Marge Schmuckal - RE: 850 Baxter Blvd - 2014-2356 - 166-A-010

From: Marge Schmuckal <MES@portlandmaine.gov>
Date: October 14, 2014 at 10:30:25 AM EDT
To: <sclark@ledgewoodconstruction.com>
Subject: 850 Baxter Blvd - 2014-2356 - 166-A-010

I am reviewing your submission of Seaside. I am seeing a new roofing plan and I am not sure where that is in the building or on the site. A site plan has not been submitted with your application. Can you submit a site plan showing where such work is happening? Your permit will be on hold until such time I can finish my zoning analysis

5 FUNDY ROAD Phone: 207-781-3344
 FALMOUTH, ME 04105 Fax: 207-699-5564
 Online @ foresidearchitects.com

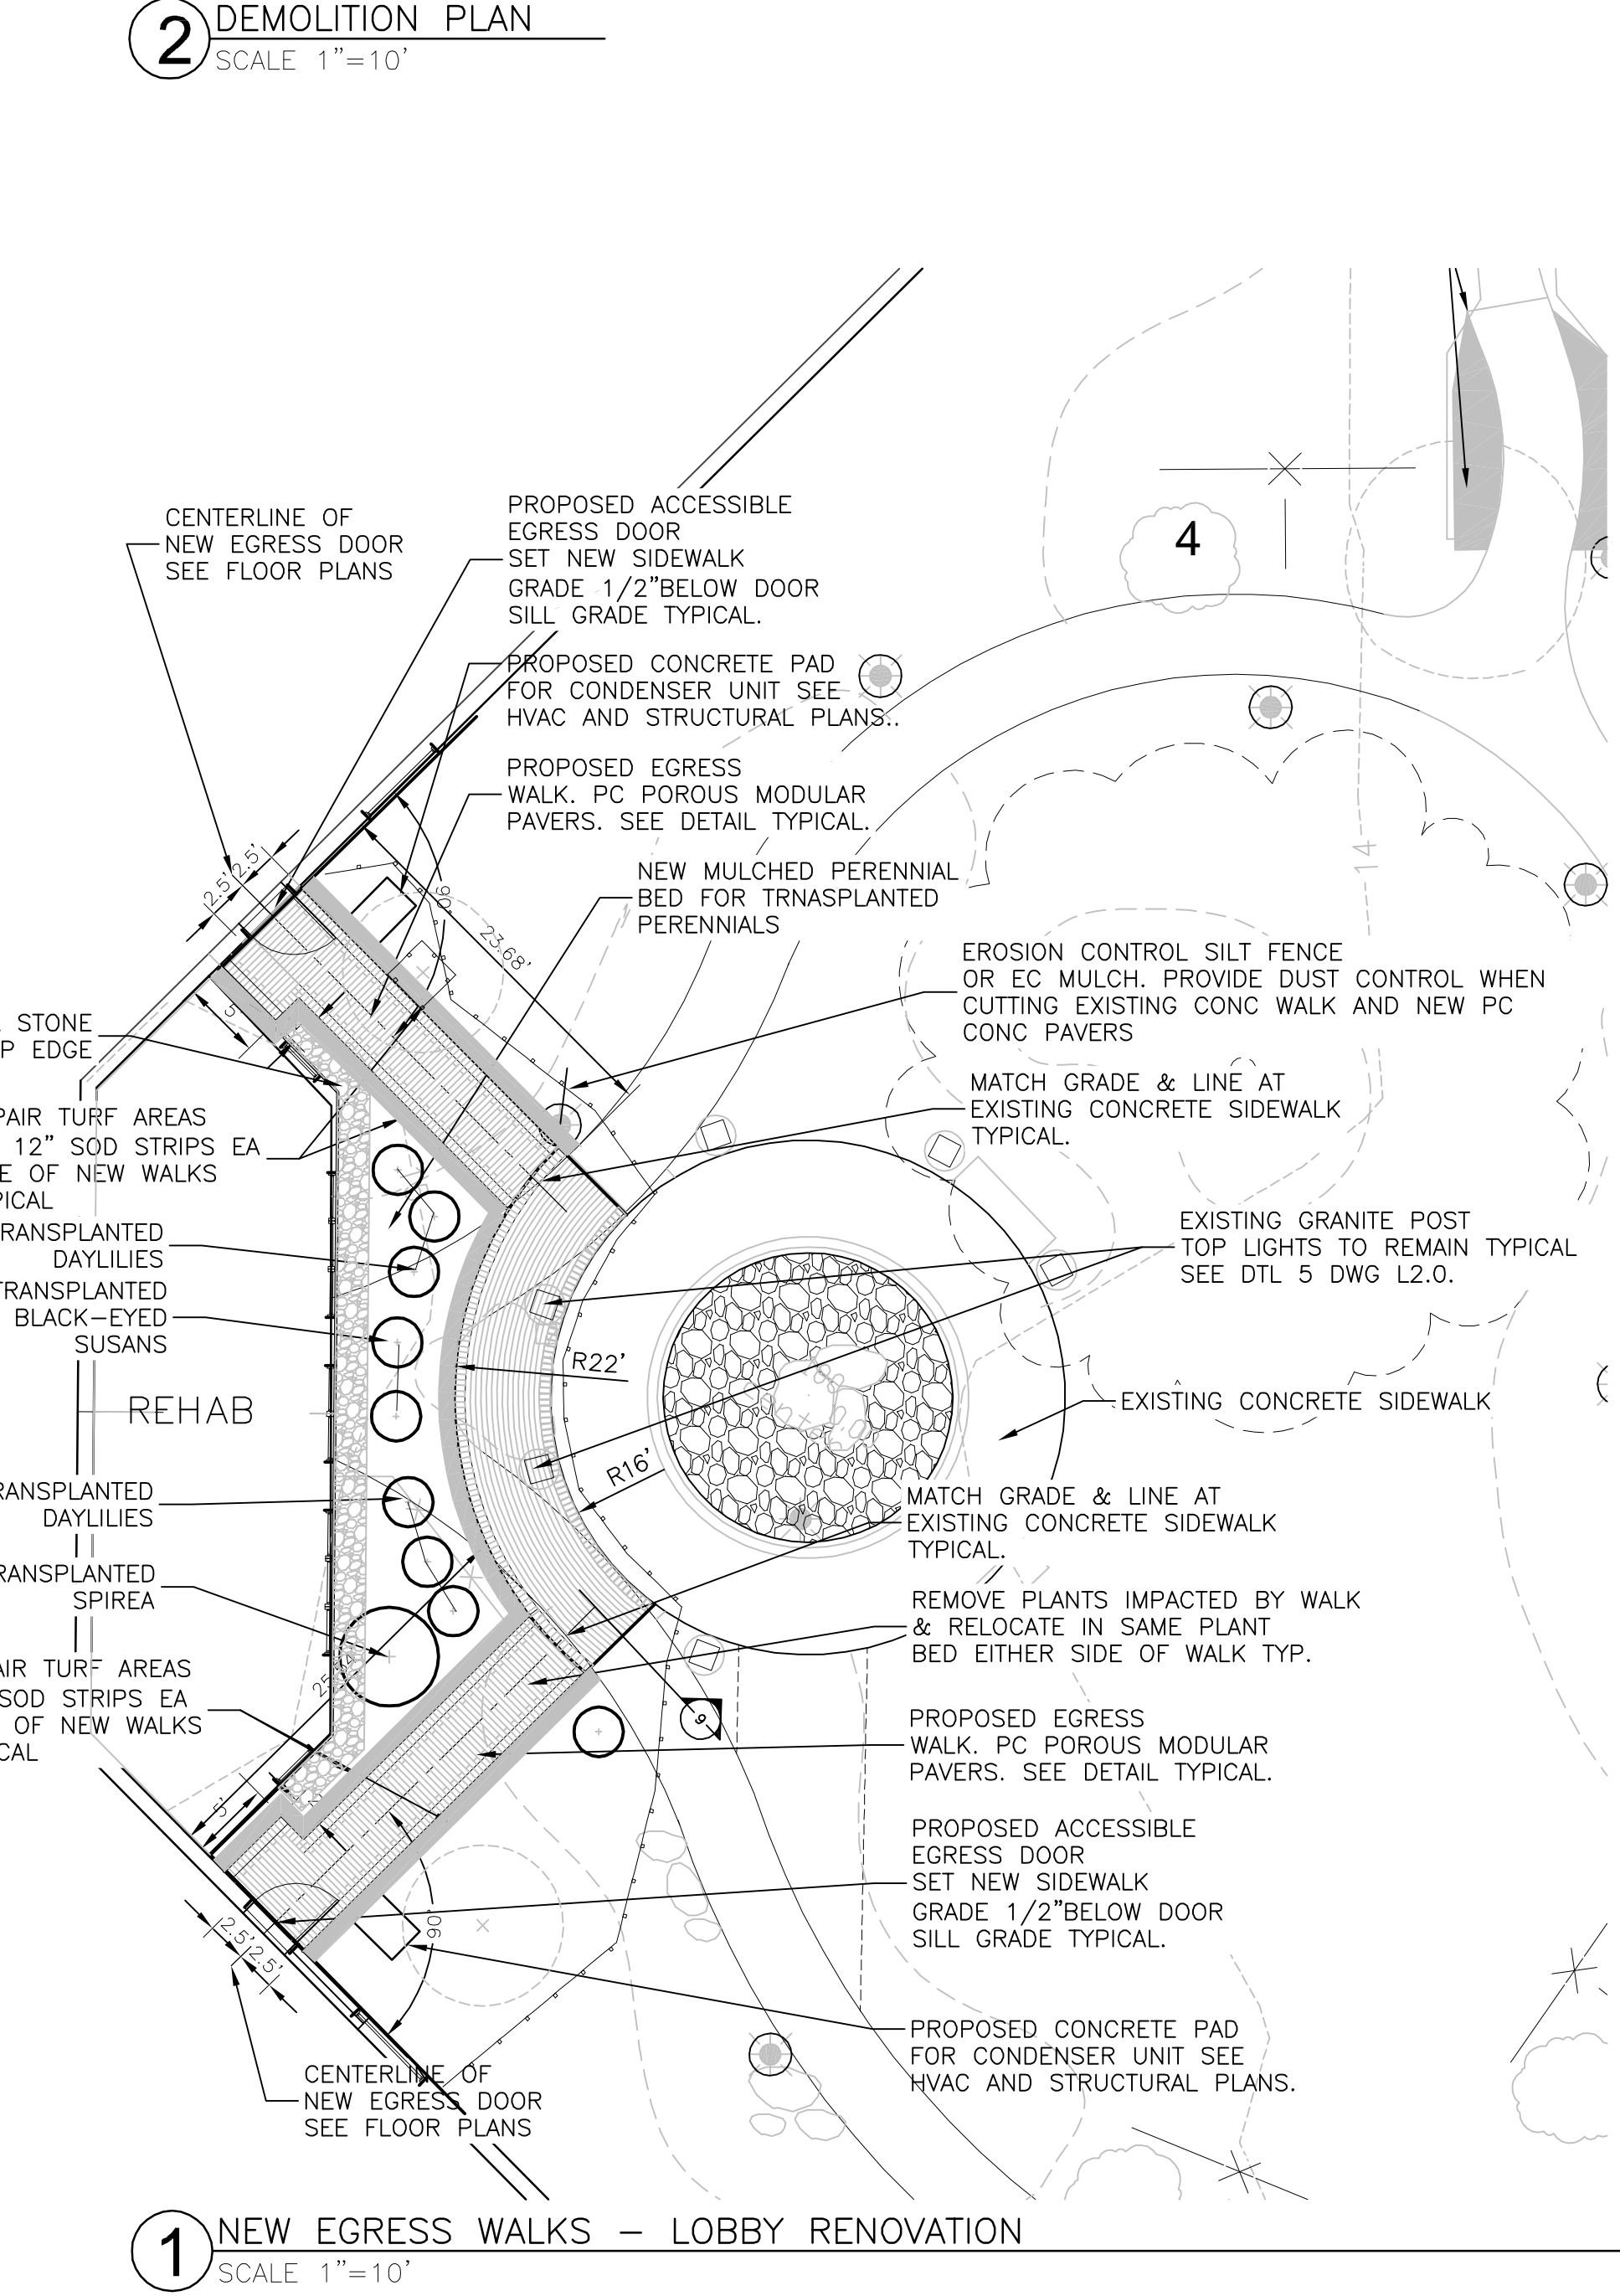
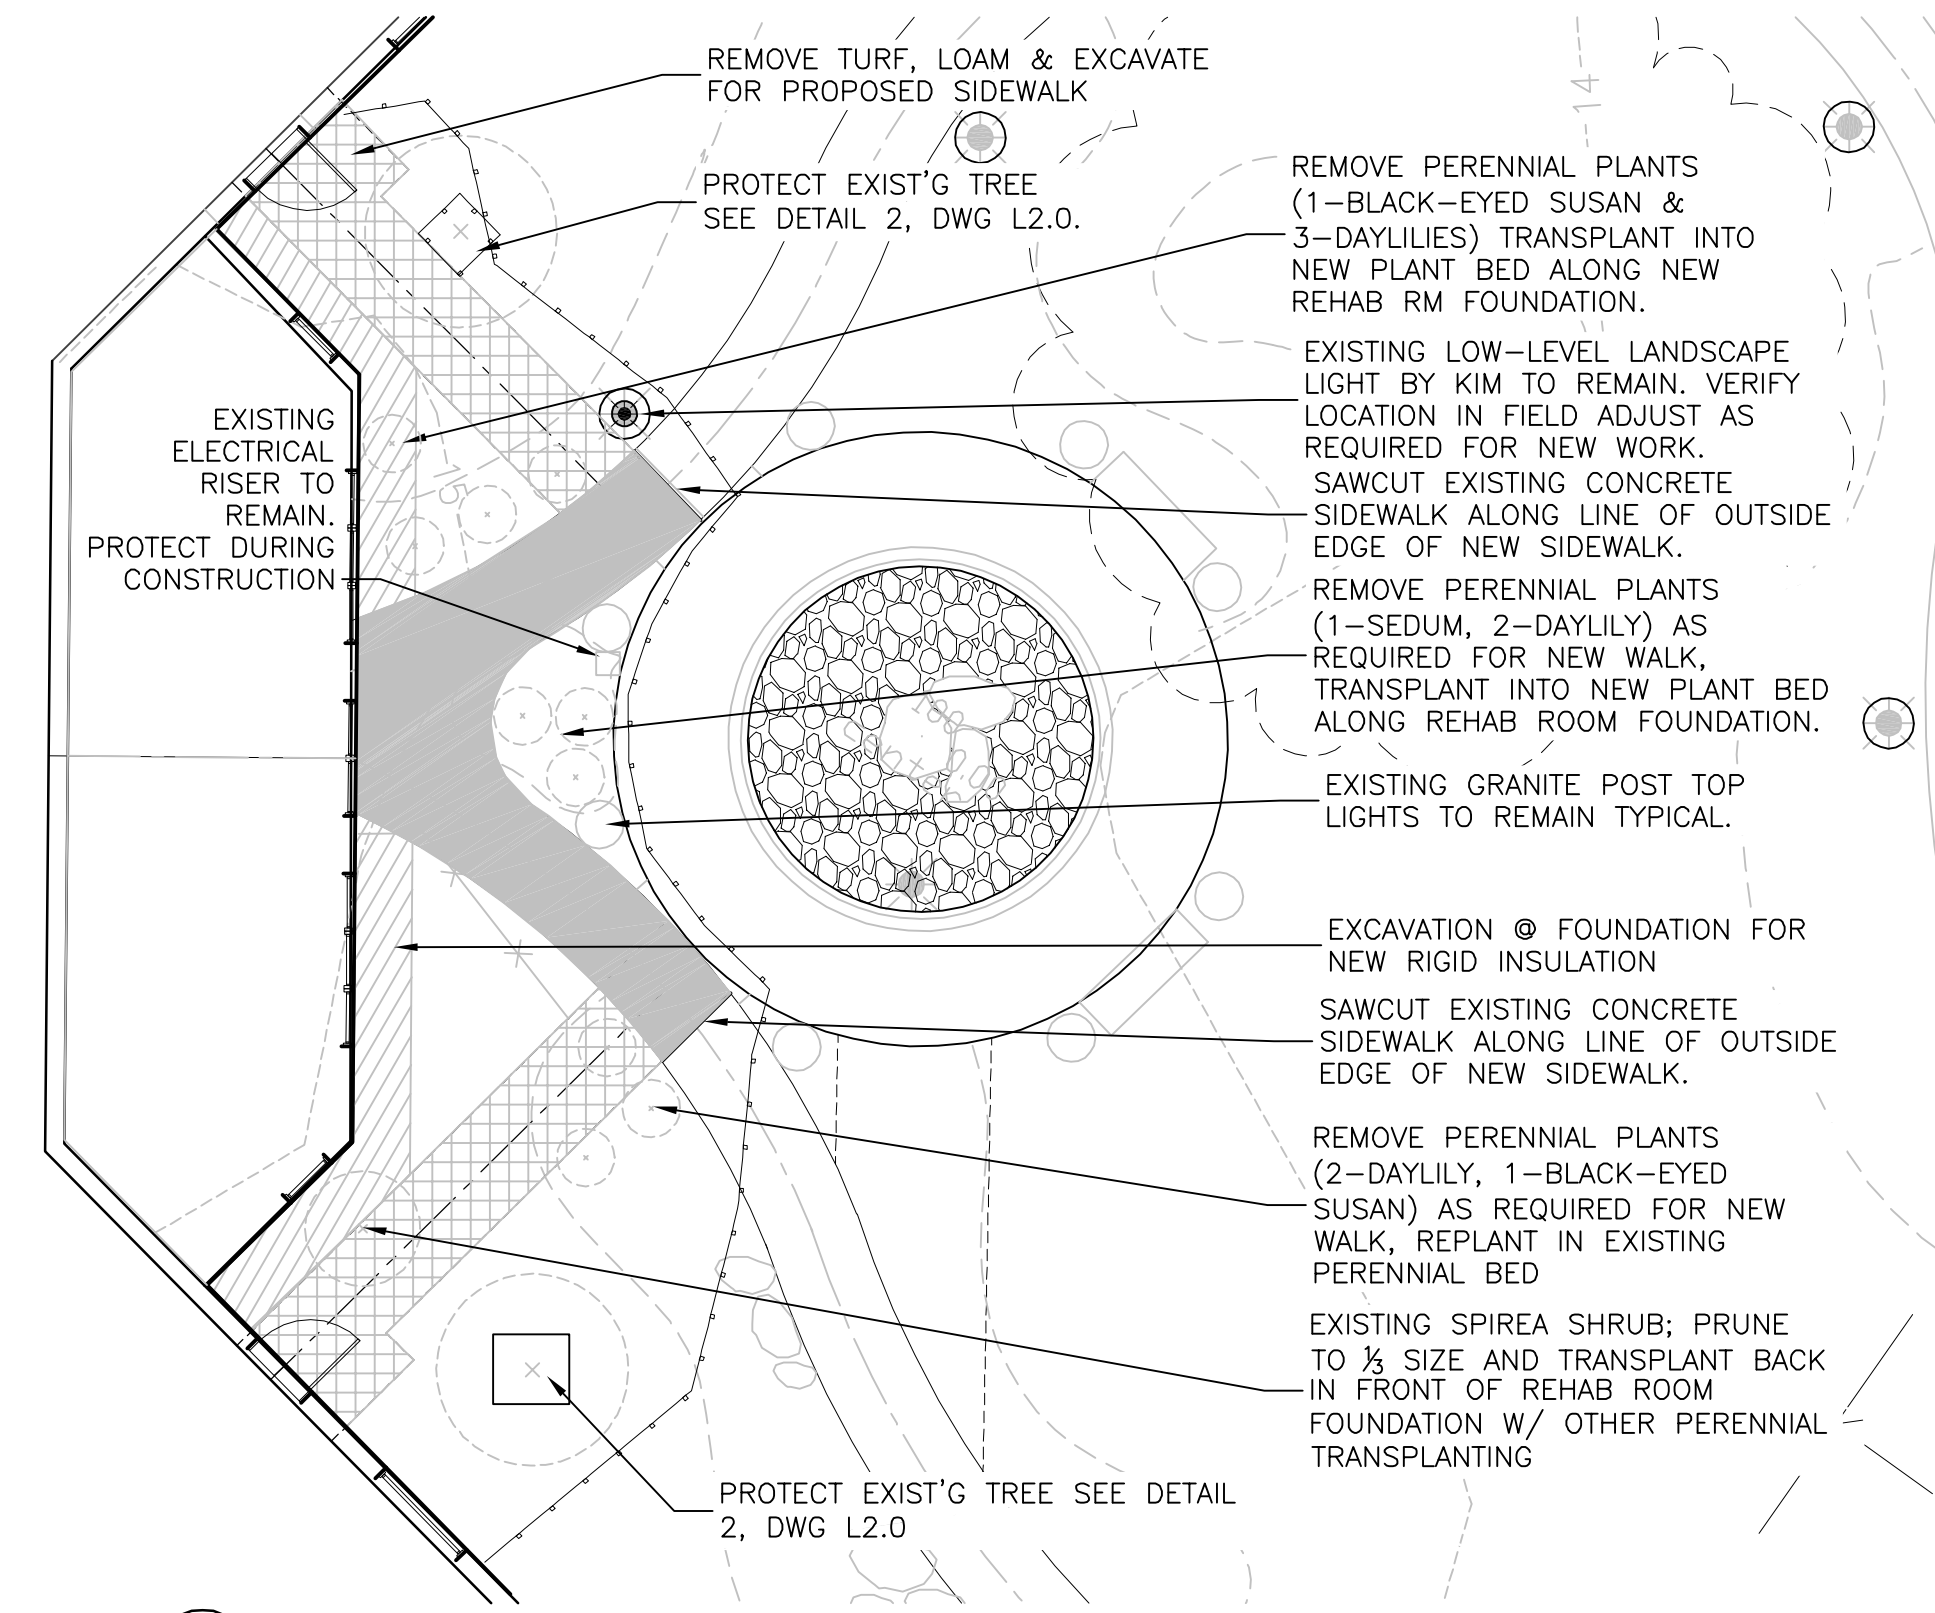
This should be shown on a site plan as to where it is located. Is all the other work interior?
Marge

We are going to need a site plan for the roof location.

See the attached site context drawing for your review.

There is a structural concrete slab at the face of the building with a low pitch roof creating an open porch. We are removing this roof, constructing walls and a new pitched roof. We are not adding to the existing footprint. Does this help or do you need additional information
